From: Robyn Shelley <Robyn.Shelley@MidCoast.nsw.gov.au>
Sent: Thursday, 22 November 2018 12:15 PM
To: Colin Phillips
Subject: RE: NSW Planning & Environment - Request Council's response to previous email dated 21 September 2018 re' Karuah East Quarry modification

I have considered the proposed modification of the approved Karuah Quarry.

The proposed extension work is mainly involved in site surface water management, some clearance and earthworks. There would be some impact on access road as the report (SLR Ref 630.12156-R01) indicates grading of road surface back to existing Dam 1 and dam 2, and embankment work. In the absence of additional information or concept drawings, the extent of embankment work, road work, and the resulting impact cannot be determined.

Figure 8: Water Management – MOD 2 Proposed Extension Area.

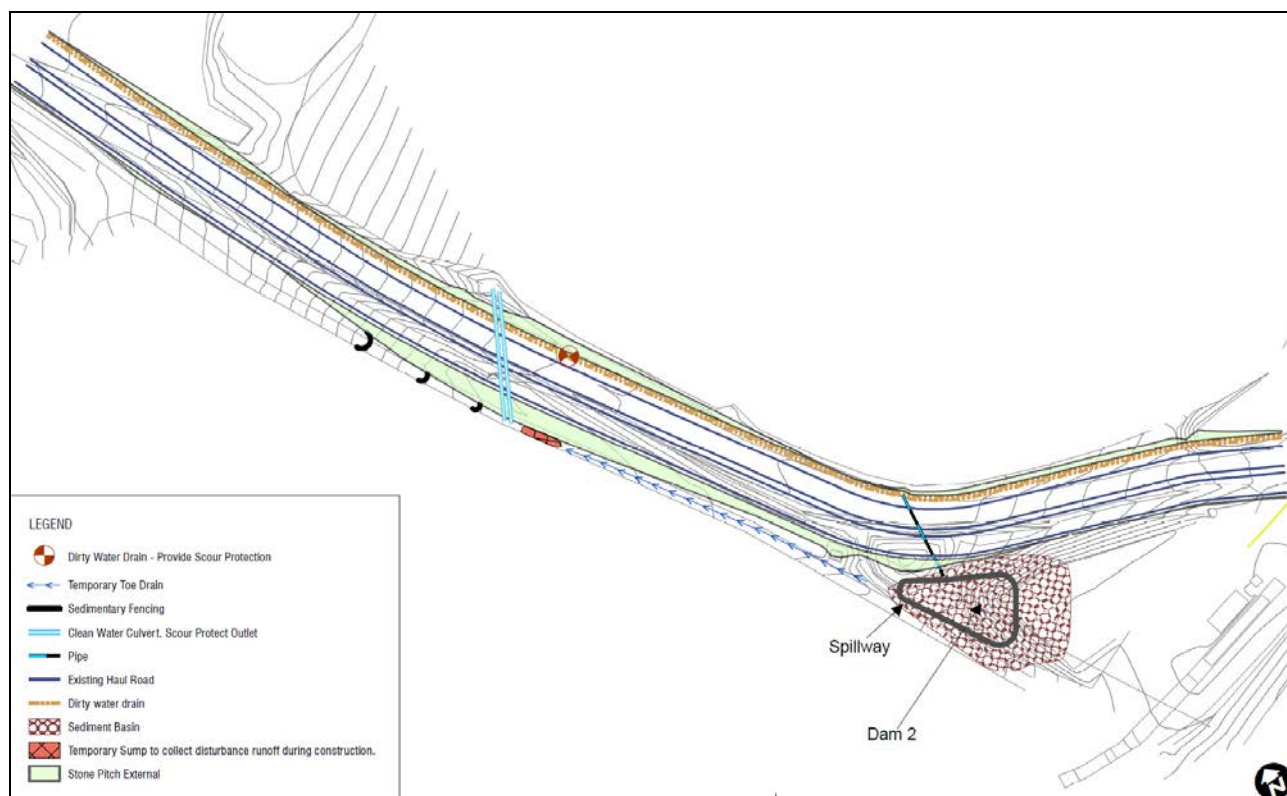
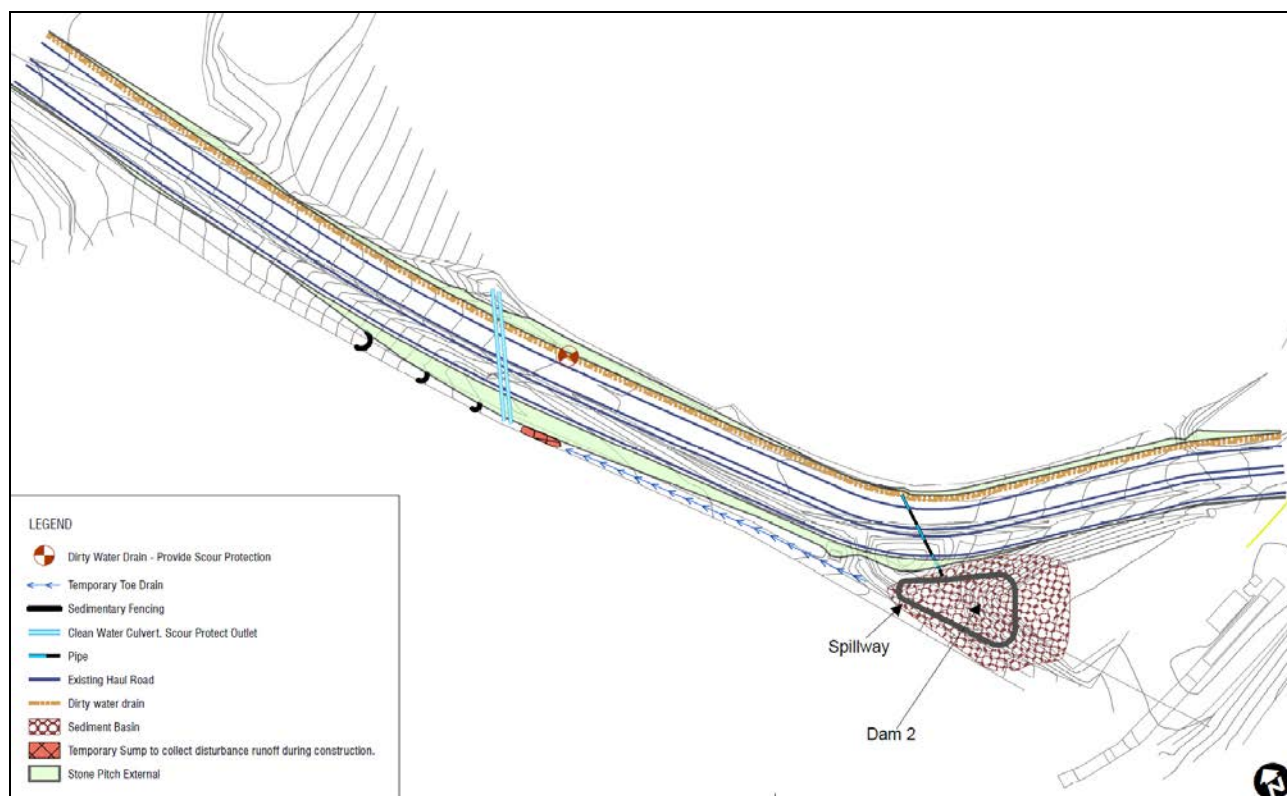
Therefore, no objections are raised to the proposed modification work in engineering point of view, on the basis of measures are in place to assure embankment work and grading on road surface are designed and constructed to relevant standards, the structural capacity of existing road pavement is maintained, and erosion and sediment control measures are in place in accordance with "Blue Book".
